10 September 2019

SSD 9667 - Light Horse Interchange Business Hub, Eastern Creek

Blacktown Council's submission to SSD 9667 - Light Horse Interchange Business Hub, Eastern Creek

Figure 5: Concept Masterplan

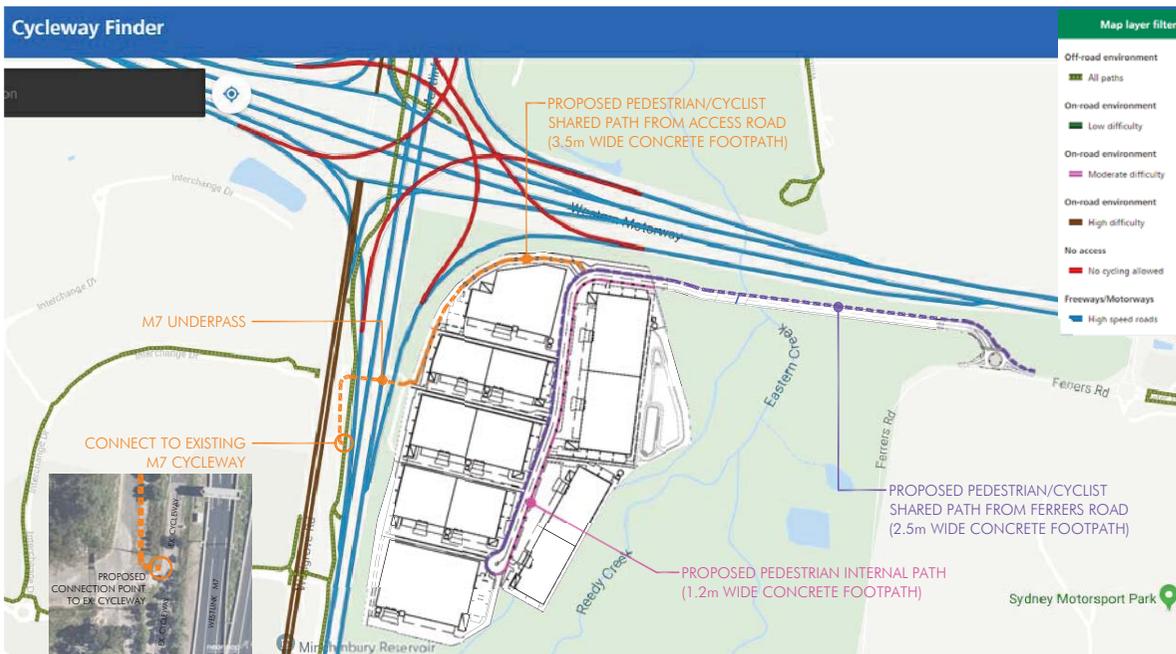
4. Consequently, we are unable to support a masterplan for buildings that nominate floor spaces for building footprints that have not been the subject of detailed assessment, especially as the building footprints are based on the parking rates in the EIS.

5. There is insufficient detail about the building footprints, including how access to docks by B-double trucks will be provided. The indicative footprints represent an overdevelopment of each site. We are only prepared to support a subdivision masterplan provided the driveways and car parking are consistent with the reciprocal rights of way.
